September 16, 2019

Re: Falcon Marketplace Final Plat (SF-19-001 CDR-16-007)

Please accept this response letter to comments received August 9th, 2019

MERIDIAN ROAD  
TURN LANE  
EXTENSION

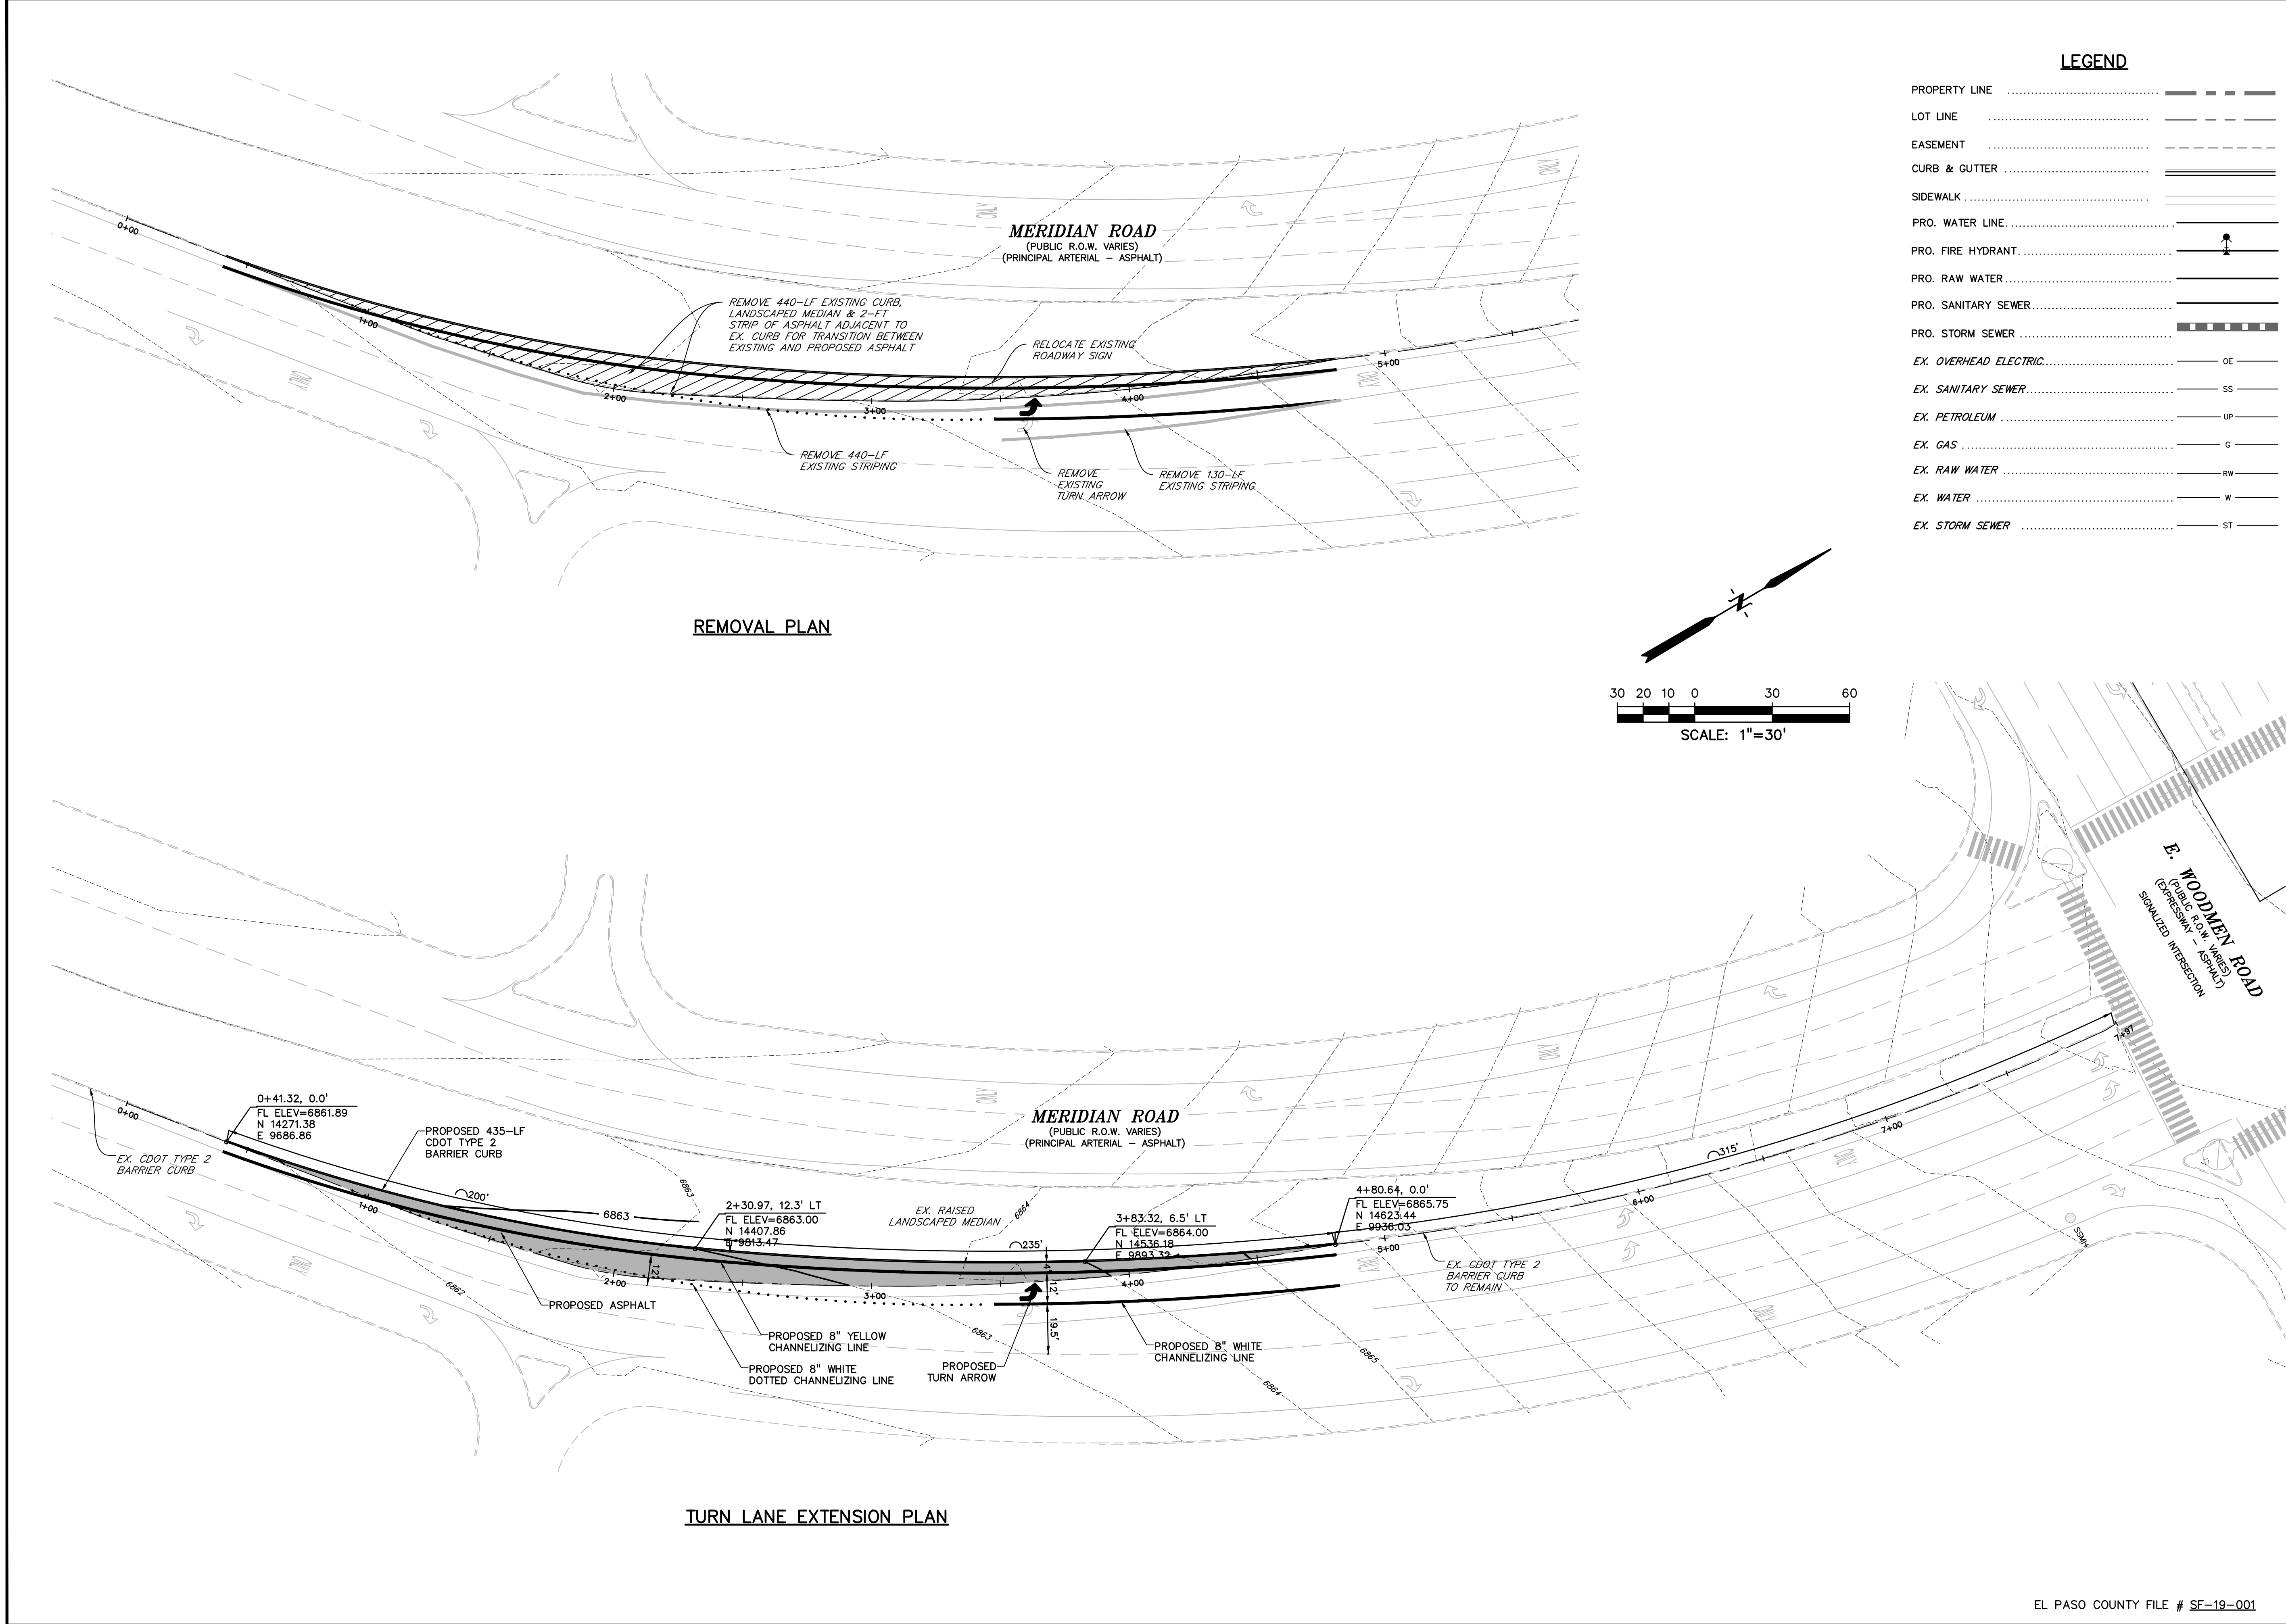
14. On Sheet C4.10 show all drainage/utility facilities next to the lane extension. Verify that guardrail is not required. **Unresolved. Show all information on the plan and address guardrail warrants, clear zone and vehicle speeds in the response. Is the check dam and north side of the ponding/channel area outside of the area of concern? Plans updated per redlines, guardrail added at pole to remain north of Eastonville intersection, and at check dam north of Woodmen Road.**
